Reference No: 2020/62/91278/W

Site Address: 75, Briarlyn Road, Birchcliffe, Huddersfield, HD3
3NW

Description: Erection of two storey extension to side and rear and
single storey rear extension

Officer Report

1790-20-003

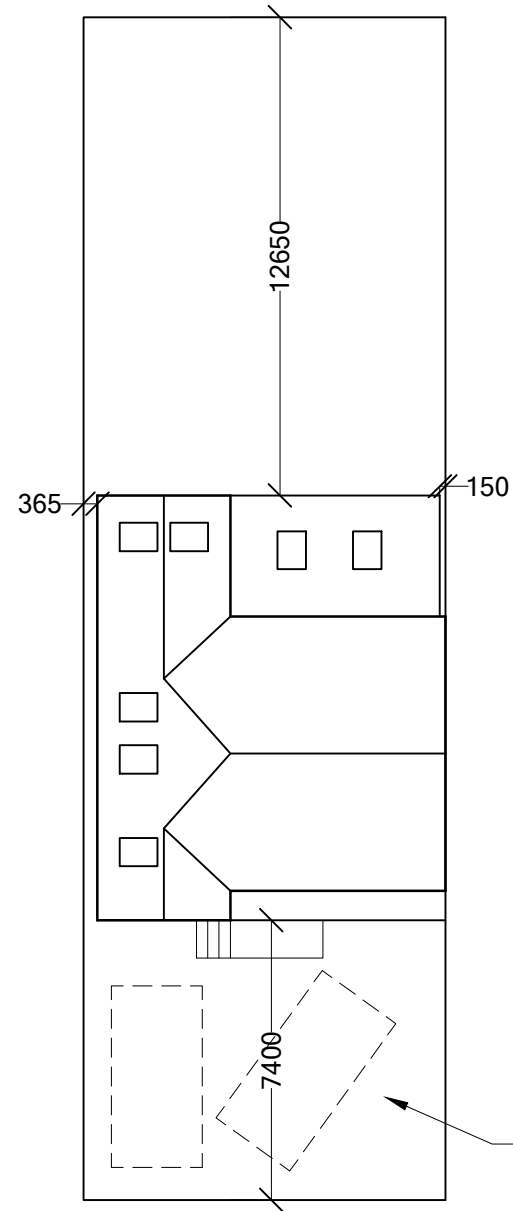
The side extension would be located on the existing driveway and therefore, to accommodate the loss of parking, the front garden would be removed and a permeable surface laid to allow and additional parking space to be formed. Highways Development Management have been formally consulted on the proposed scheme and have raised no concerns regarding the development. As such, the proposal is considered to comply with Policy LP22 of the Kirklees Local Plan with regard to parking. A condition shall be imposed to ensure that this area is constructed from a permeable surface.

4. The development shall not be brought into use until all areas indicated to be used for the parking of vehicles on the submitted plan have been marked out, and laid out with a hardened and drained surface in accordance with the Communities and Local Government; and Environment Agencies 'Guidance on the permeable surfacing of front gardens (parking areas)' published 13th May 2009 (ISBN 9781409804864) as amended or any successor guidance. Notwithstanding the provisions of the Town and Country Planning (General Permitted Development) Order 2015 as amended (or any Order revoking or re-enacting that Order) these areas shall be so retained, free of obstructions

CLIENT :	Gareis		
ADDRESS :	75 Briarlyn Road Birchcliffe HD3 3NW		
PROJECT :	Proposed Plans & Elevations		
DATE :	Apr 2020		
ISSUE :	PLANNING:	B.REGULATIONS:	GENERAL:
	<input checked="" type="radio"/>	<input type="radio"/>	<input type="radio"/>
DRAWING REF :	REVISION:	SCALE:	
1790-20-004	A	1-50

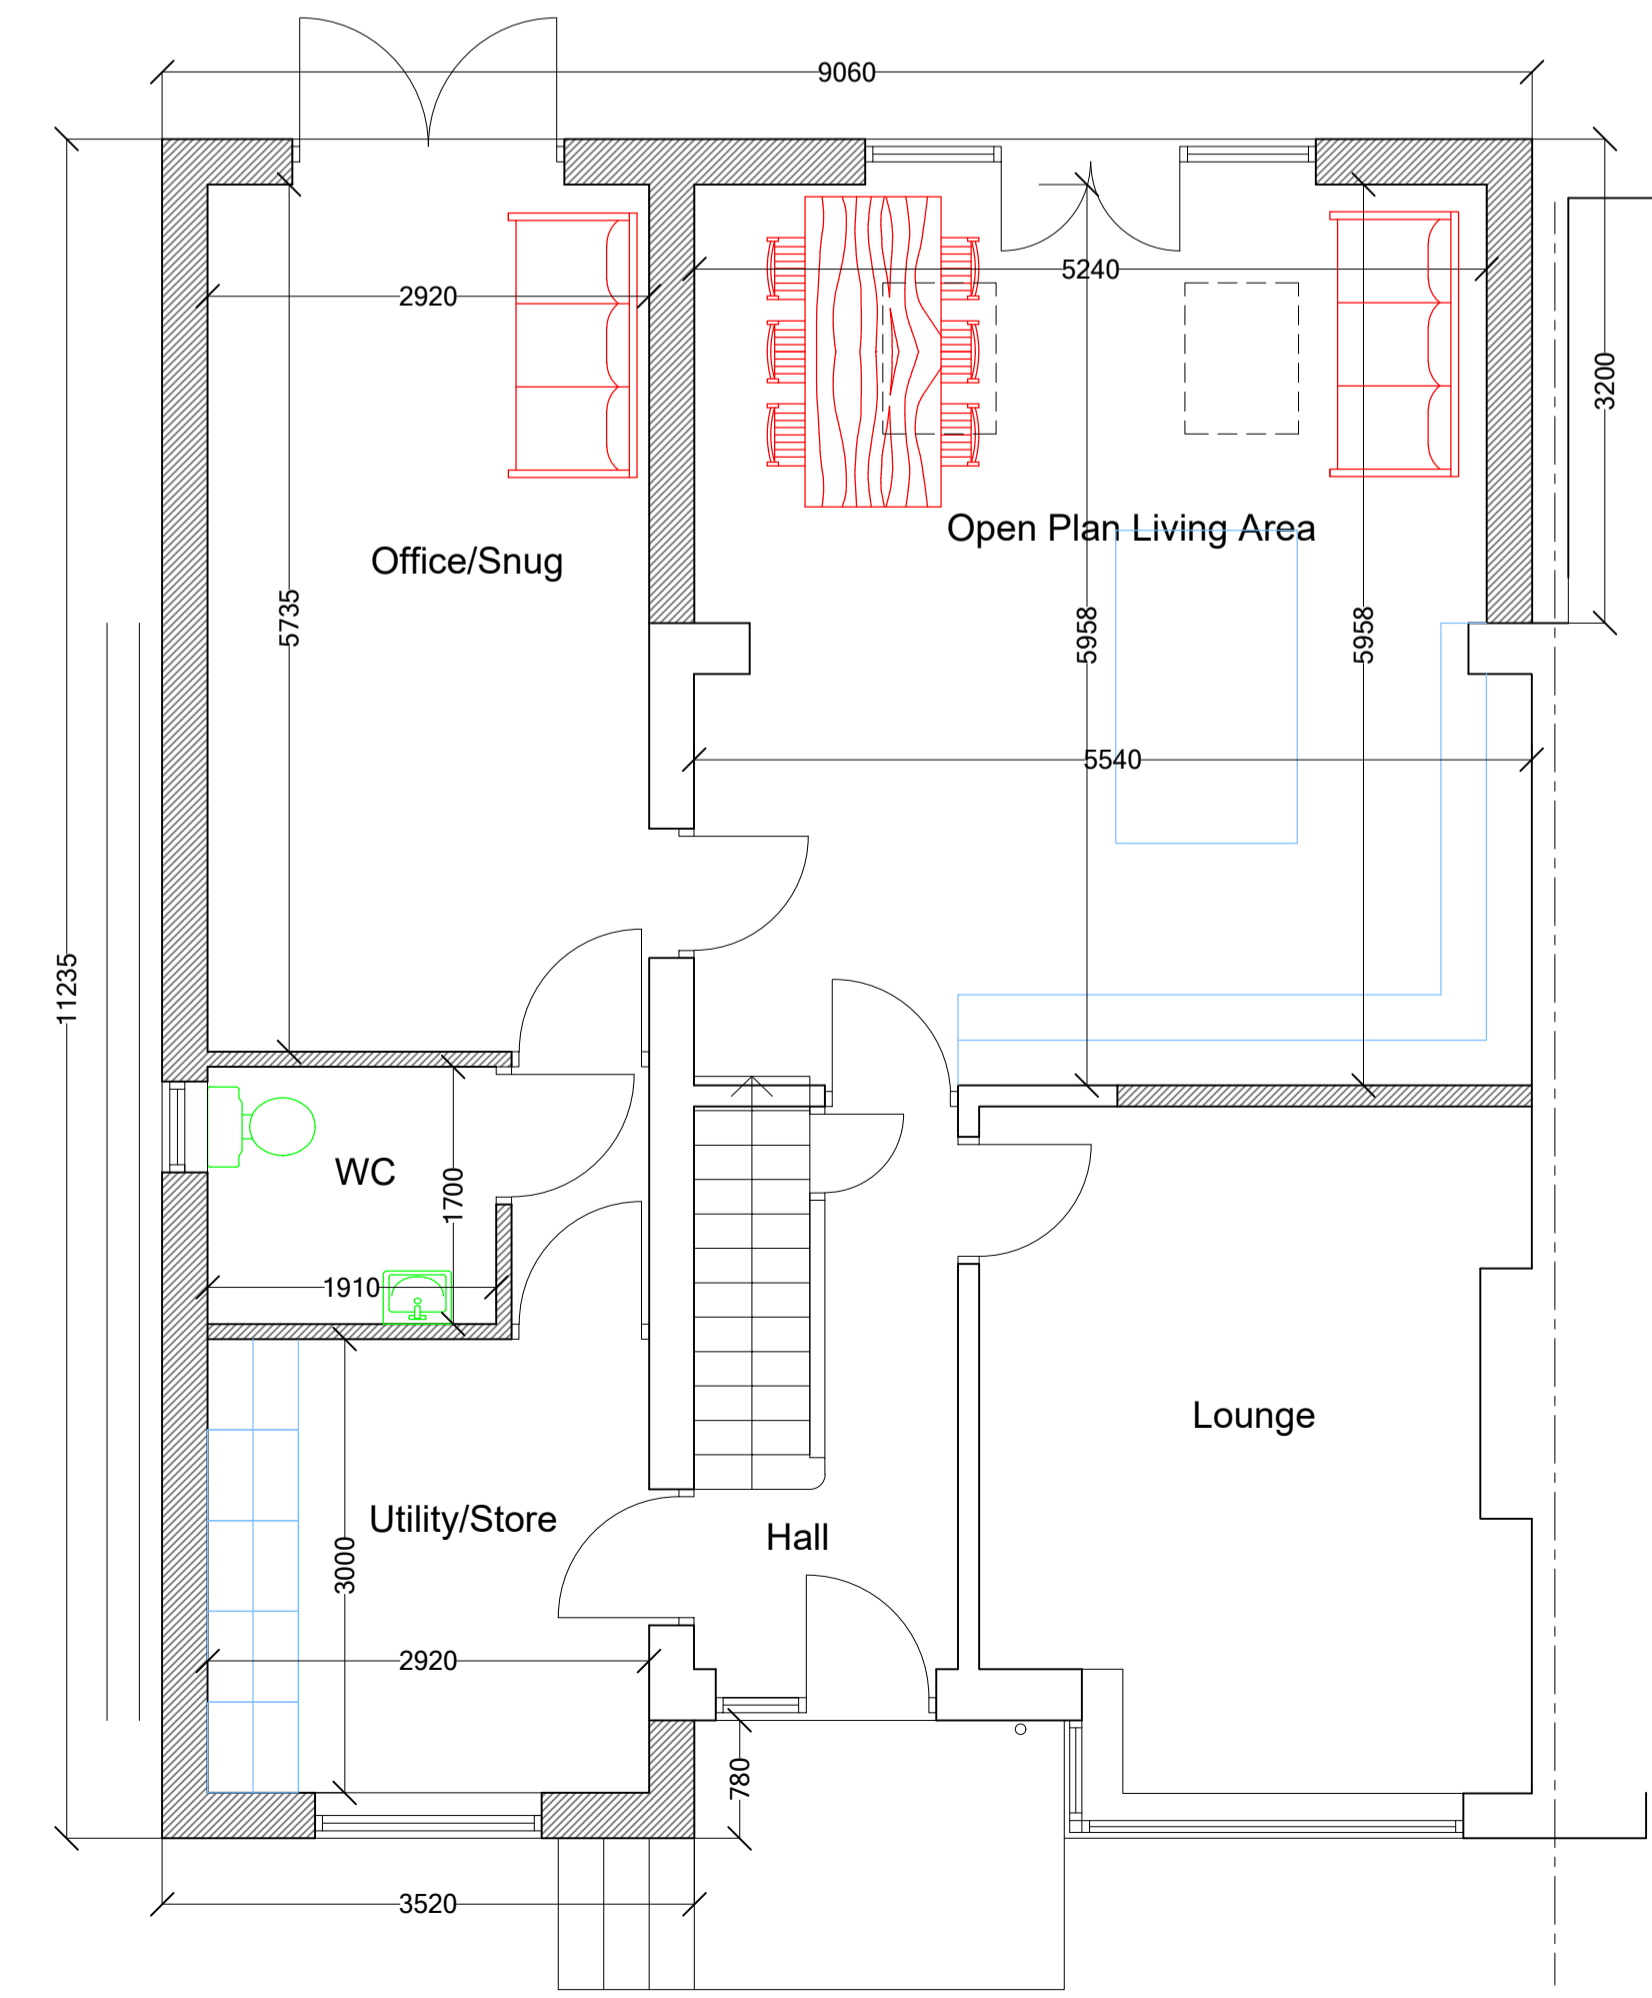
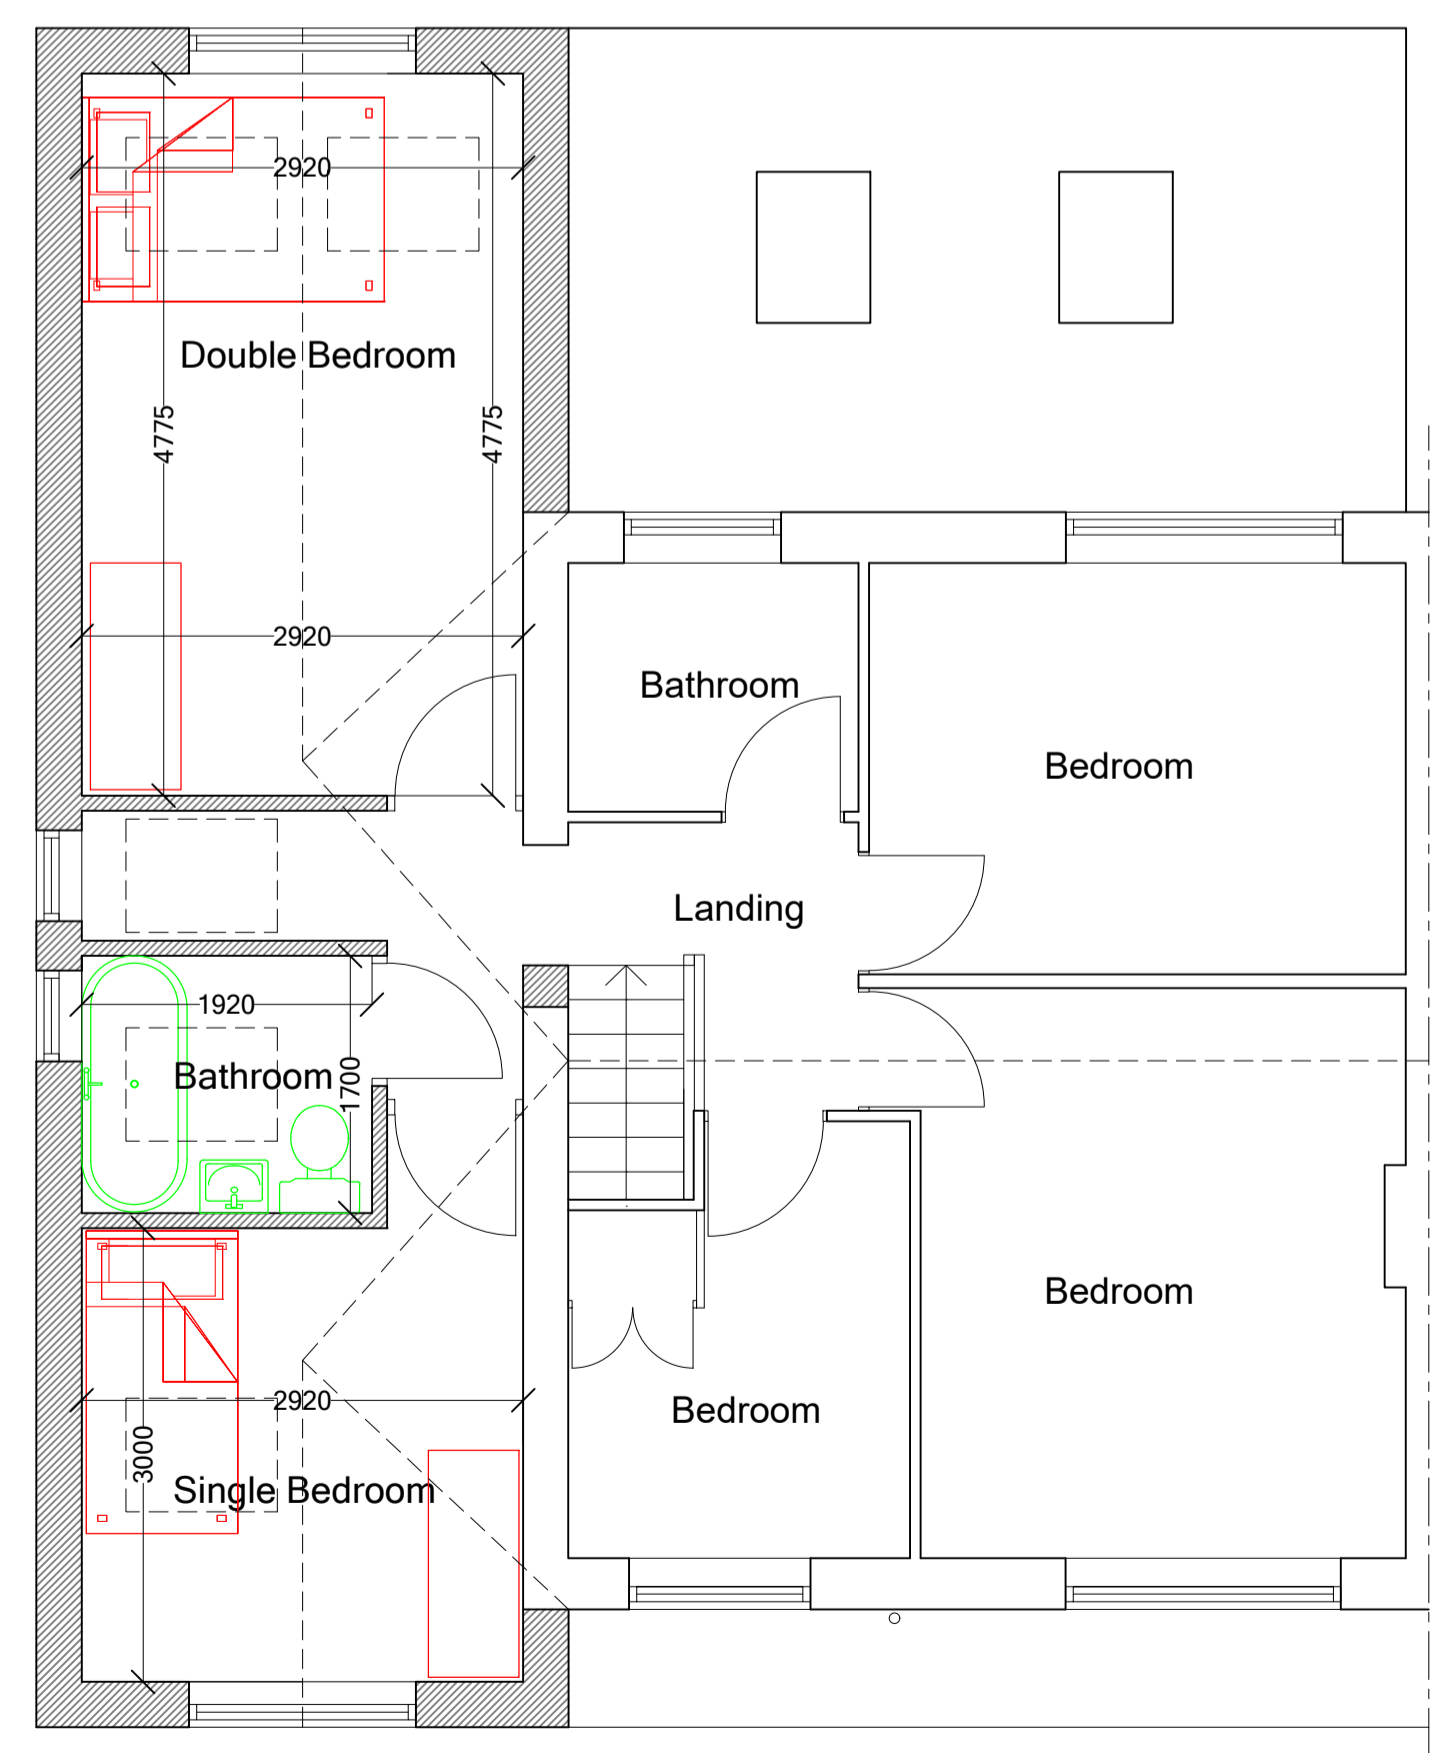
Following raising concerns regarding the size, scale and massing of the proposal, a site visit was undertaken. Following this, the Agent was contacted and it was requested that the projection of the extension beyond the rear boundary was reduced from 3.8 metres to 3.2 metres. Amended plans were submitted to reflect this request. The application is therefore assessed in conjunction with the amended plans received on 14th September 2020.

The design is such that the two storey element of the extension would have an eaves height and roof ridge height to match the existing. The extension would also be slightly forward of the front elevation. Whilst this would result in a structure that would not be subservient to the host dwelling, there are a number of properties within the immediate area which have similar designs to this proposed which includes No's 17 and 69 Briarlyn Road. As such, whilst the extension would be large, it would be in keeping with other extensions already constructed in terms of design. Concerns were raised in relation to the overall size, scale, bulk and massing of the proposal and as a result, a site visit was undertaken. Following discussions it was requested that to reduce both the visual harm and harm to residential amenity that the rear section of the single and two storey extension be reduced from a projection of 3.8

In terms of the impact on No. 73, this property is set on a lower ground level than the application site by approximately 1.4 metres. No. 73 has a single storey extension on the side of the property which projects approximately 2 metres beyond the rear of the property. Due to the application property being located to the south of No. 73, there would be some element of overshadowing to the amenity area of No. 73 in the evening hours as the sun drops to the west although this is not considered significantly reduce the enjoyment of the amenity space or living conditions of the neighbouring property. There is, however, massing and bulk on the shared boundary, which is escalated by the drop in land levels, although the scheme has been amended to reduce the bulk to a degree where it is considered not to unduly oppressive upon the neighbouring property particularly in the garden area. This has resulted in the projection off the rear of the property being reduced from 3.8 metres to 3.2 metres reducing the massing when viewed from the neighbouring amenity space.

There is a first floor opening within the side elevation of the neighbouring property however this appears to be obscurely glazed and therefore, it is not considered that the harm from overshadowing and being overbearing to this opening would be significant. There are openings proposed within the side elevation of the extension which would be to a WC at ground floor and bathroom and landing at first floor. Whilst these are non-habitable room openings, due to the proximity of the openings to No. 73, it is considered reasonable and necessary to attach a condition to ensure these are obscurely glazed.

metres to 3.2 metres and amended plans were submitted. It is therefore considered that the design of the scheme is now acceptable.

3. The development shall not be occupied until the windows in the side elevation of the two storey extension hereby approved have been obscure glazed to level 4, or equivalent, as specified by Pilkingtons Glass range. Notwithstanding the provisions of the Town and Country Planning (General Permitted Development) Order 2015 as amended (or any Order revoking or re-enacting that Order) the obscure glazing as such shall thereafter be retained for the lifetime of the development.
